**Jeanie Bourke - Re: 7 Salem St., BP#2015-02604 plan review comments**

**From:** Jeanie Bourke  
**To:** Keith Marple  
**Date:** 1/5/2016 1:33 PM  
**Subject:** Re: 7 Salem St., BP#2015-02604 plan review comments  
**CC:** ron petrone

# Stair Details

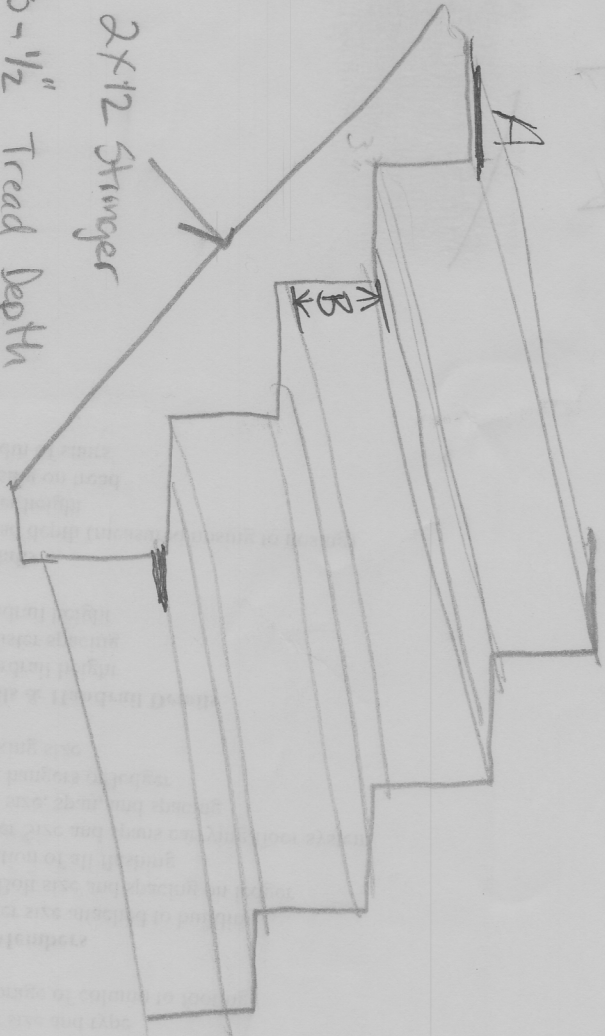
I just left you a voice message. I will approve the permit with conditions, please pay close attention to these. There are some items that are not clear such as if the decks and stairs will be in the exact footprint. The rise and run for a 3 unit is 7" by 11" with no nosing. If you are restricted by the footprint, the stairs may not comply with this. Any stairs that can comply, should, ie. the steps to grade.

Keep in mind that because this is a multifamily building, the code reference is the IBC and as such, the stair rise and run, guard and handrail dimensions shall be shown accordingly. Include spacing of balusters, guard height, additional graspable handrails (both sides), tread profile with no nosing (commercial).
